Consultation Response from KC Highways		
2019/92221 Kenmore Caravans Ltd, 119, Huddersfield Road, Mirfield, WF14 9DA		
Outline application for demolition of existing buildings and erection of Class A1 retail unit, access, car parking, servicing, landscaping and associated works		
Date Responded: 31/03/2020	Responding Officer: Mark Berry	Responding Ref: 10-5NE-01
This application seeks outline approval for demolition of existing buildings and erection of Class A1 retail unit, access, car parking, servicing, landscaping and associated works (all matters reserved other than access) at Kenmore Caravans Ltd, 119, Huddersfield Road, Mirfield. The highways consultation response dated 23rd August concluded that this application provided insufficient information as follows: 1, The application is supported by a Transport Assessment (TA) prepared by Turner, Lowe Associates. The scope of the Transport Assessment was not agreed with Highways Development Management, and did not include capacity analysis of the Doctor Lane and Stocks Bank Road junctions and the Huddersfield Road and Station Road signalised junction. The TRICs data was not included with the TA and the traffic generation figures qu

Project:	Huddersfield Road. Mirfield
Title:	Huddersfield Road / Station Road / Queen Street
File name:	Mirfield 2025.lsg
Author:	J Lowe
Company:	Turner Lowe Associates
Client:	Morbaine
Notes:

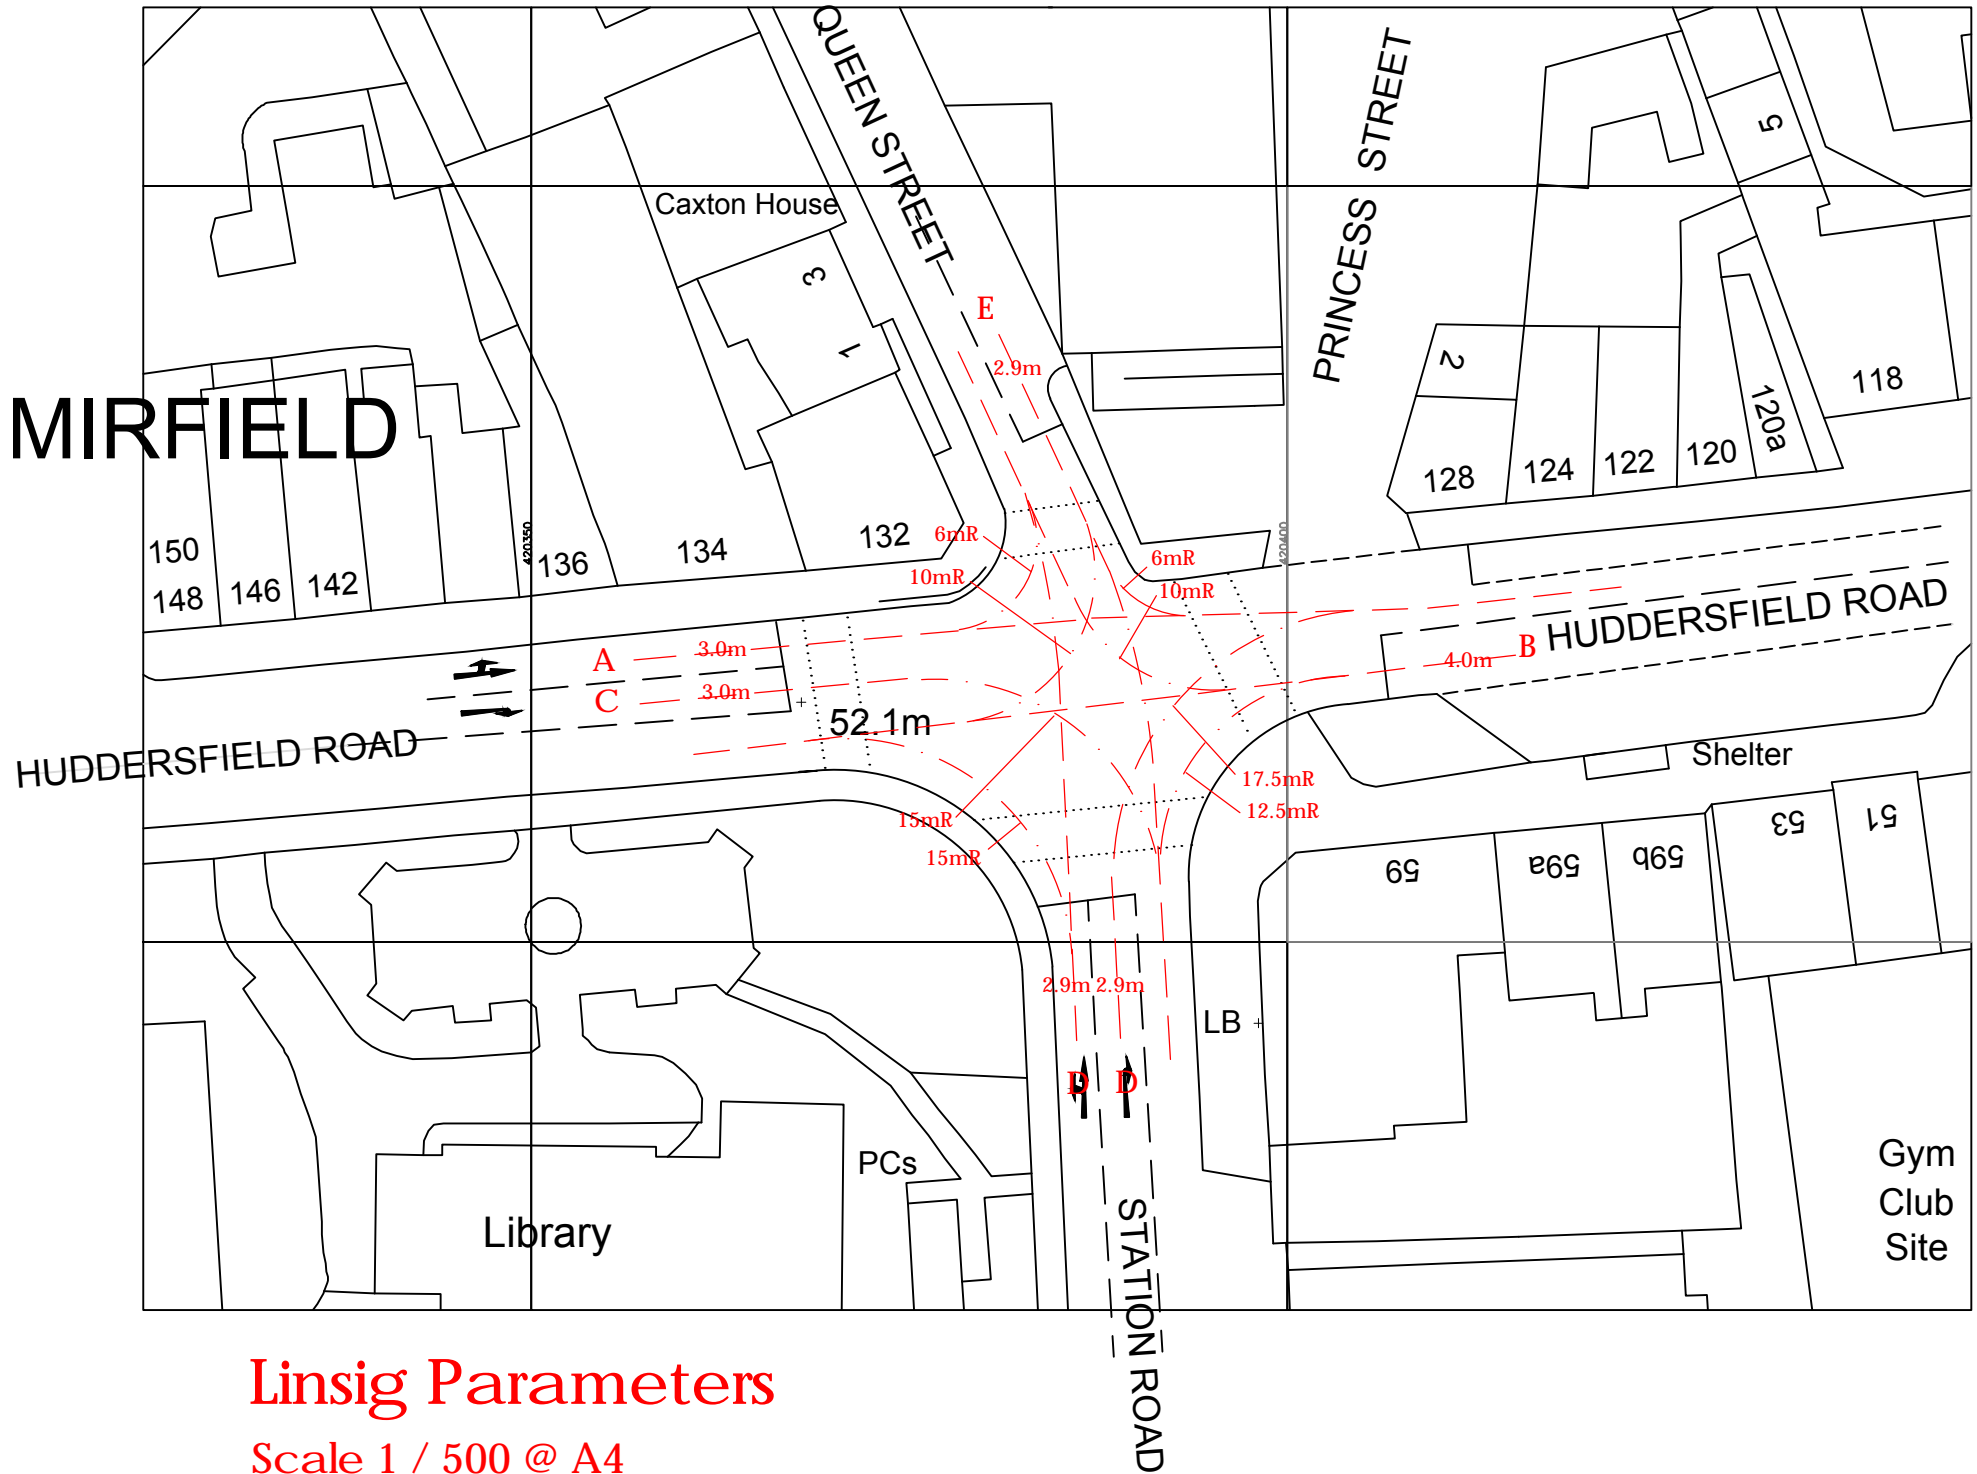
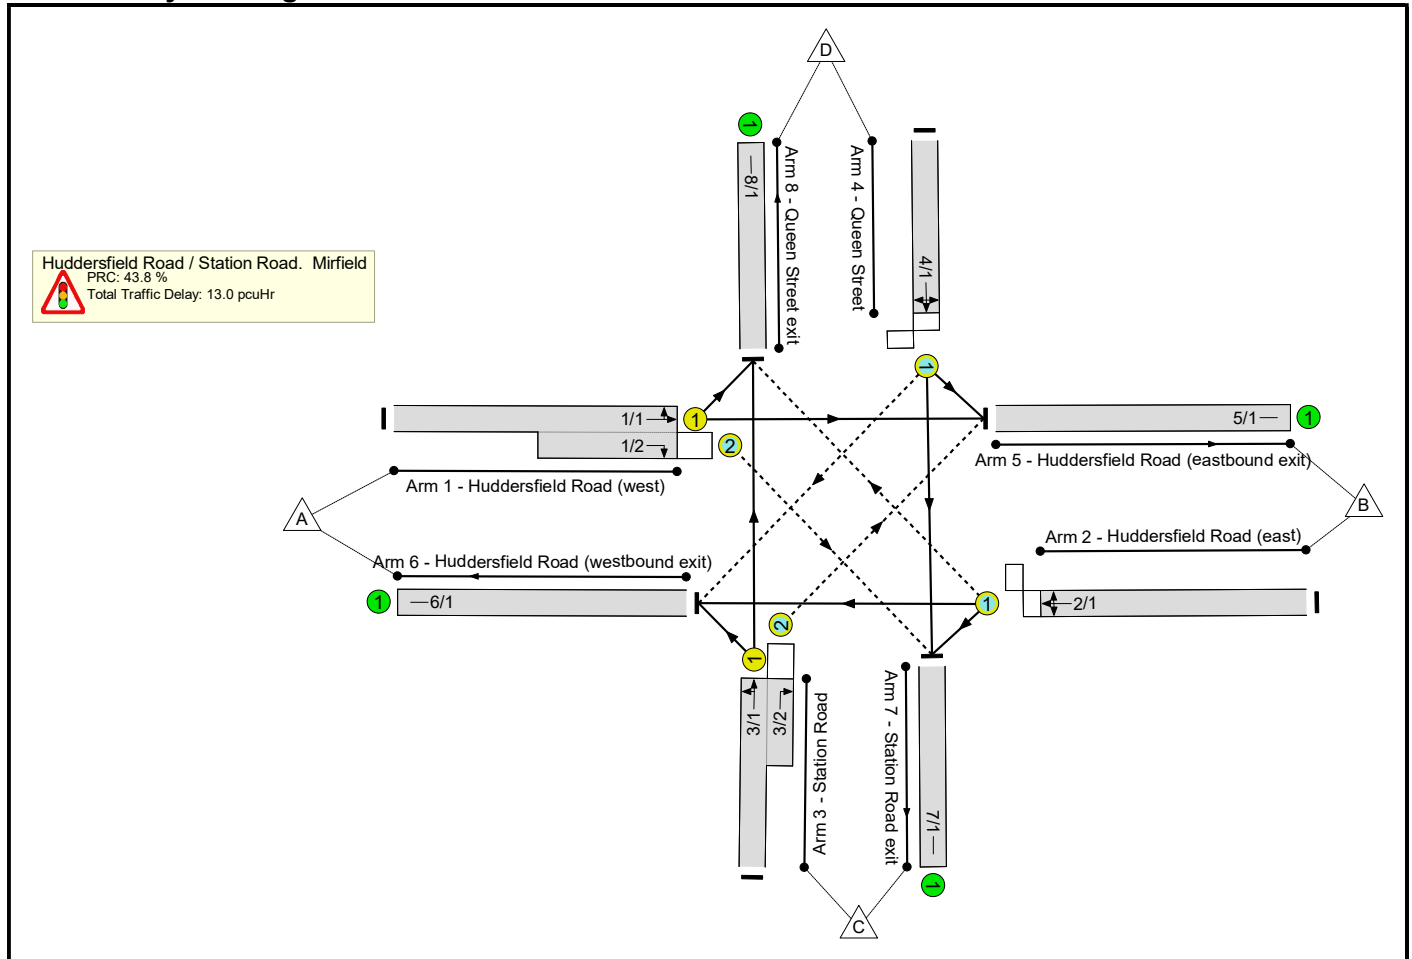
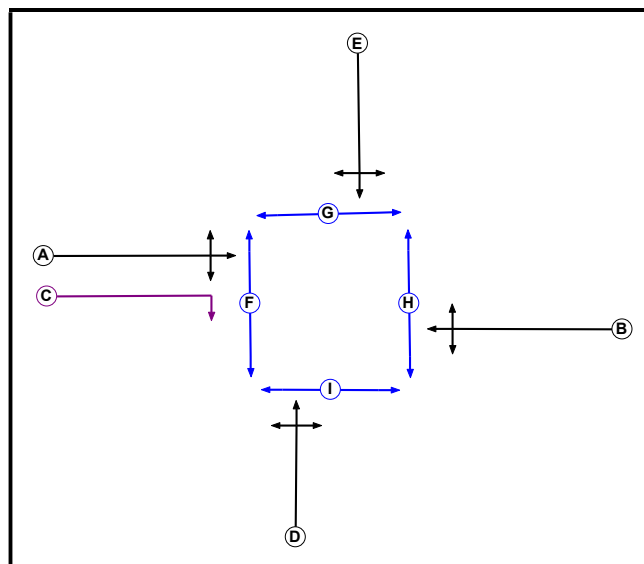
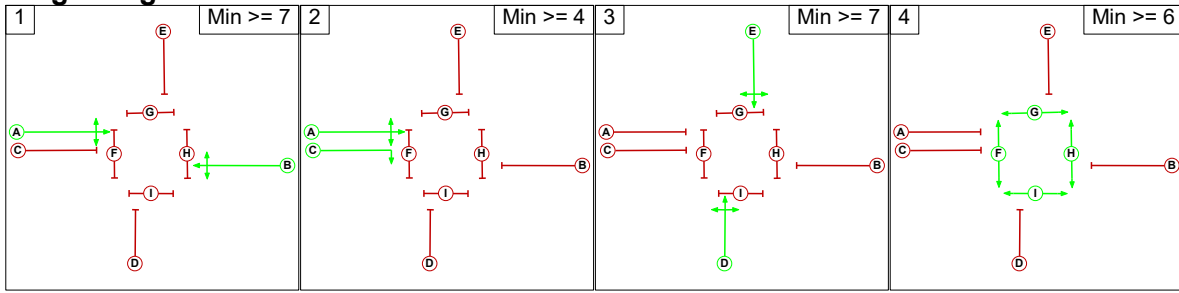
The councils traffic signals Engineers (UTMC) have assessed the Linsig modelling:

They applicants hadn't purchased a controller specification from UTM C and most of the (critical) timing information within the model was incorrect. UTM C have however made corrections and re-modelled the junction.

The revised model does show that there is a minor improvement in Practical Reserve Capacity at the junction as a result of the development presumable as a result of traffic diverted from other stores in the area.

The table below shows the change in Practical Reserve Capacity as a result of the development – this includes the values from the applicants original modelling to show just how incorrect their data was and the impact that can have on models (they had underestimated all the inter-greens and some of the phase lengths).

**Proposed Development
Huddersfield Road.
Mirfield.
Site Layout and Access
Arrangements**

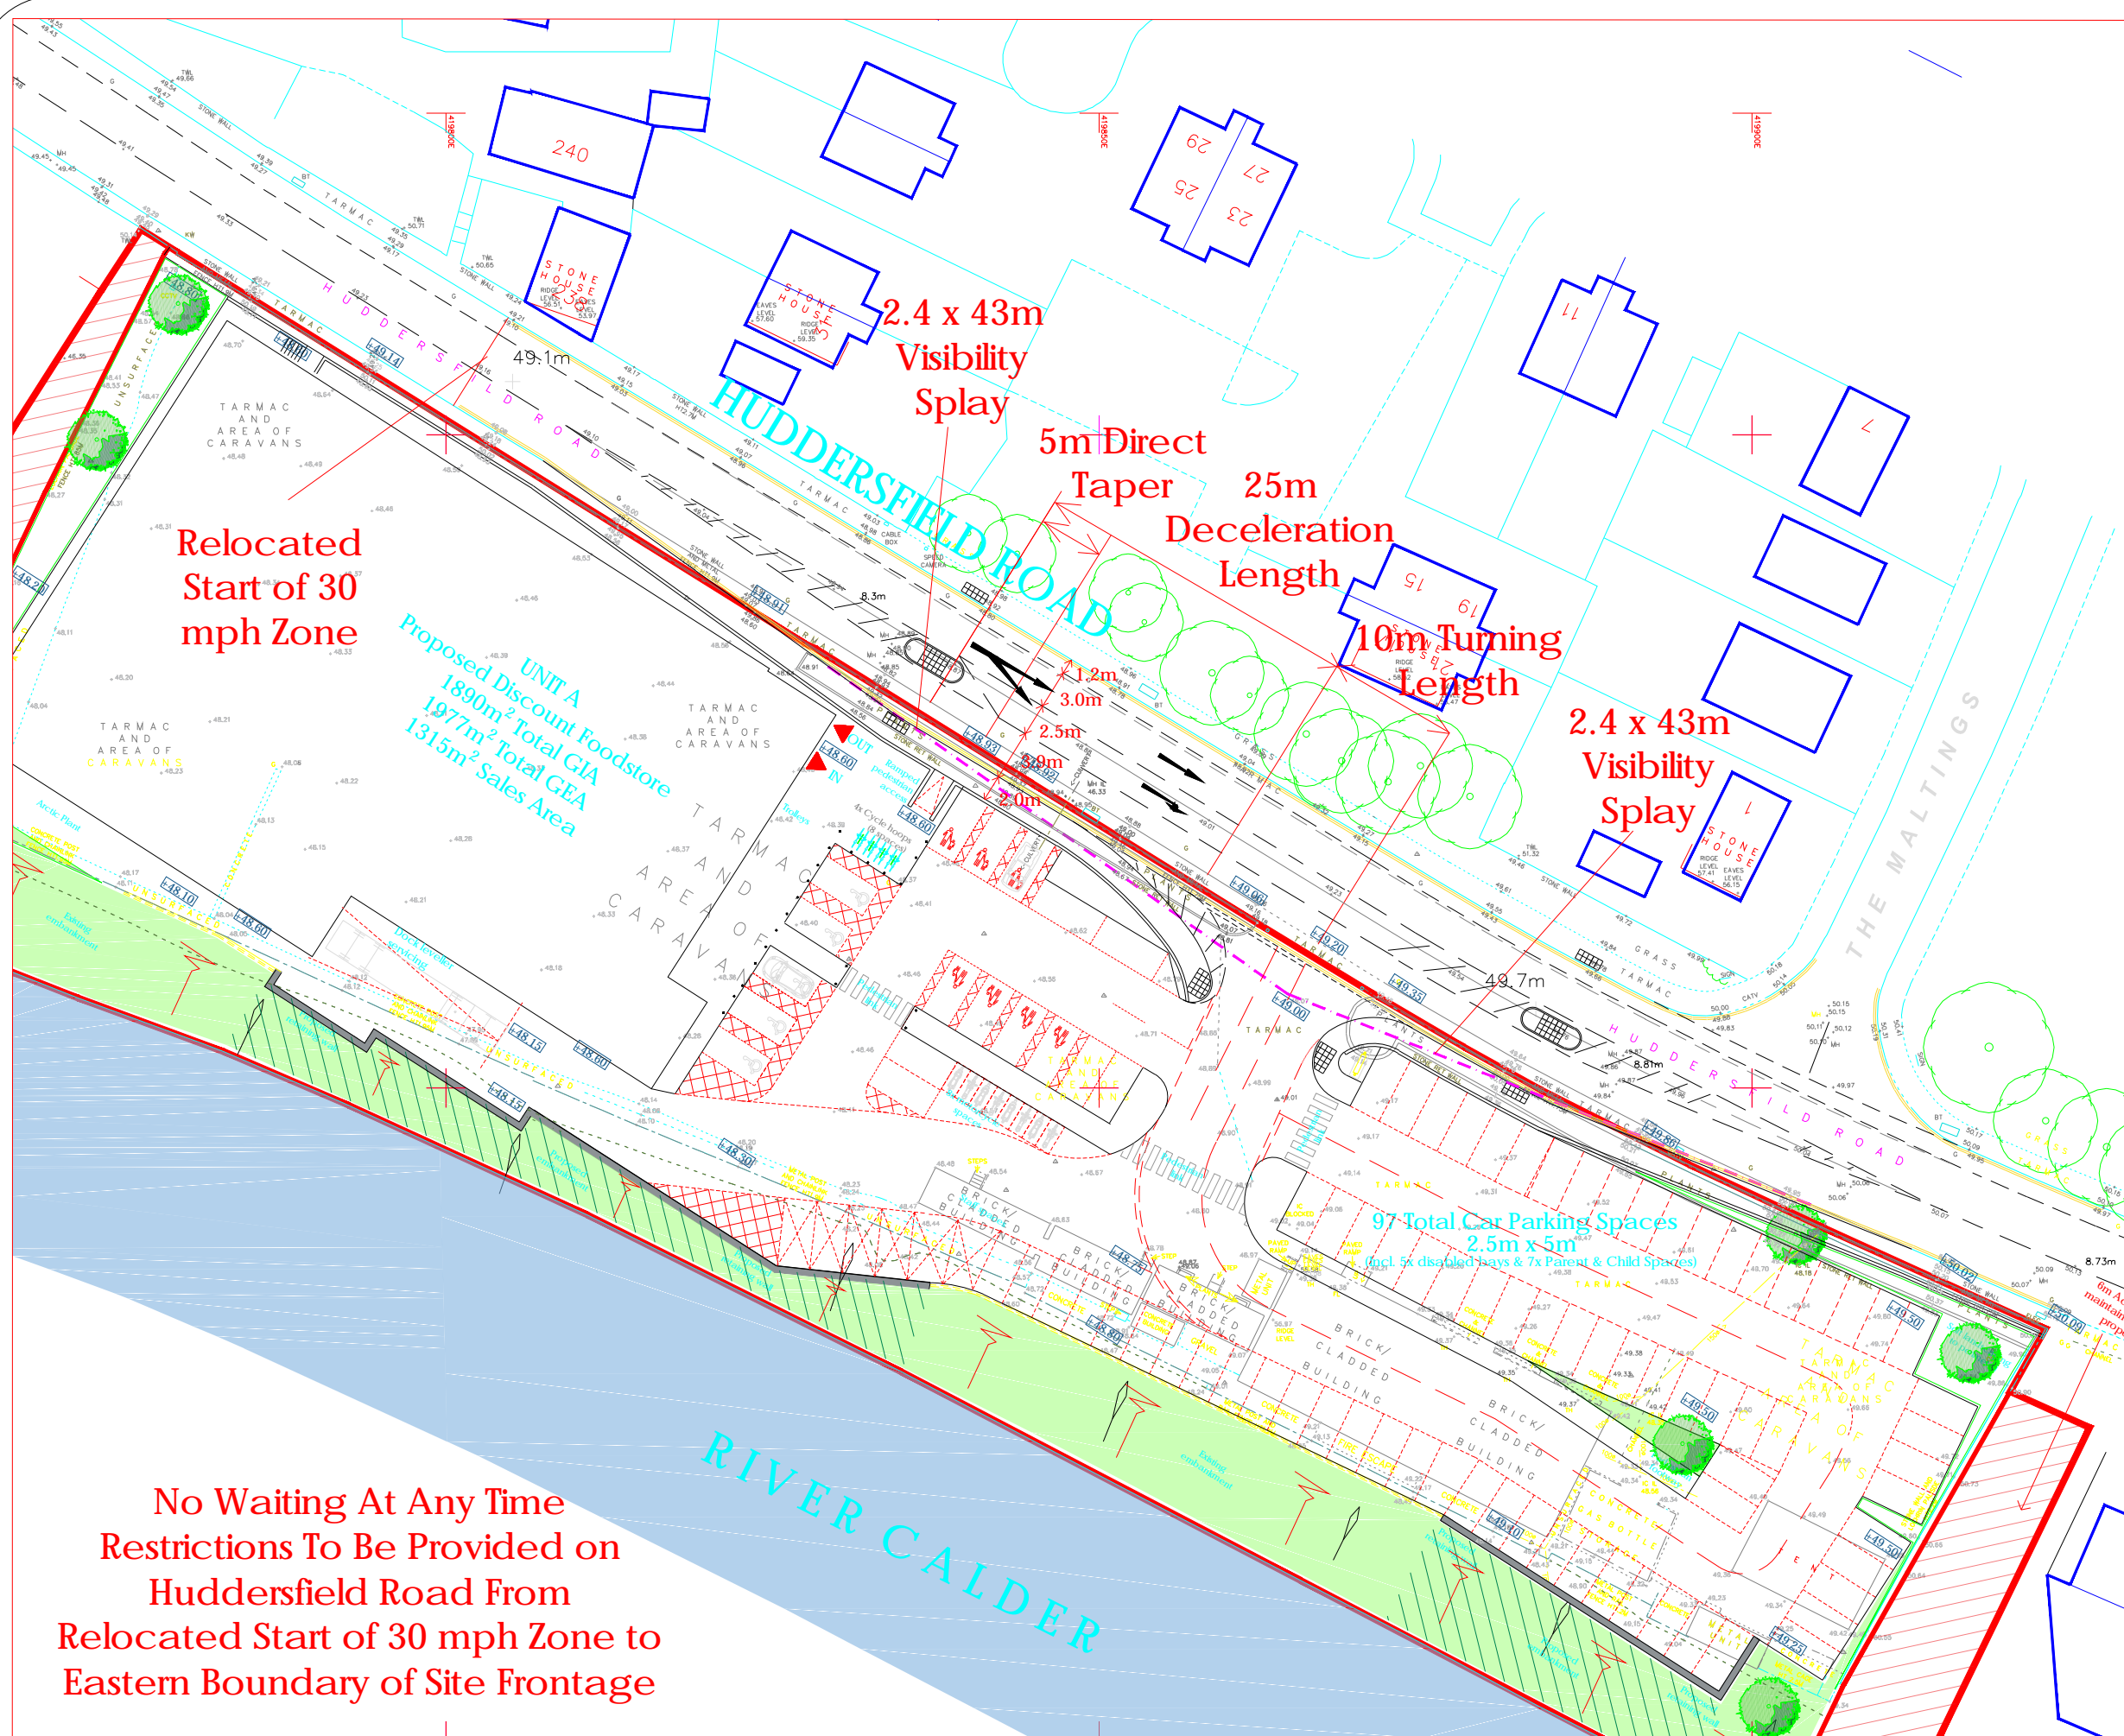
A right turn lane into the development is now shown to be provided together with improvements to the pedestrian facilities along Huddersfield Road.

The extent of the 30mph speed limit along this section of Huddersfield Road is shown to be extended to include the access to the proposed store, the visibility requirements on to Huddersfield Road are shown based on the reduced speed limit, acceptable swept paths for a 16.5m articulated vehicle are provided and motorcycle and cycle parking is shown on the revised plans.

No Waiting at Any Time Restrictions are proposed to both sides of Huddersfield Road to the full frontage of the site.

The proposals show a single point of access onto Huddersfield Road with the provision of a right turn lane and pedestrian refuges along Huddersfield Road. 97 car parking spaces are proposed including accessible spaces and parent and child spaces within a car park on the eastern section of the site. Cycle and motorcycling parking spaces are shown to be provided.

Prior to development commencing, a detailed scheme for the provision of a right turn lane from Huddersfield Road into the site and new pedestrian refuges with associated signing and white lining shall be submitted to and approved in writing by the LPA. The scheme shall include construction specifications, white lining, signing, surface finishes and transport regulation orders together with an independent Safety Audits covering all aspects of the work. Unless otherwise agreed in writing by the LPA, all of the agreed works shall be implemented before any part of the development is first brought into use.
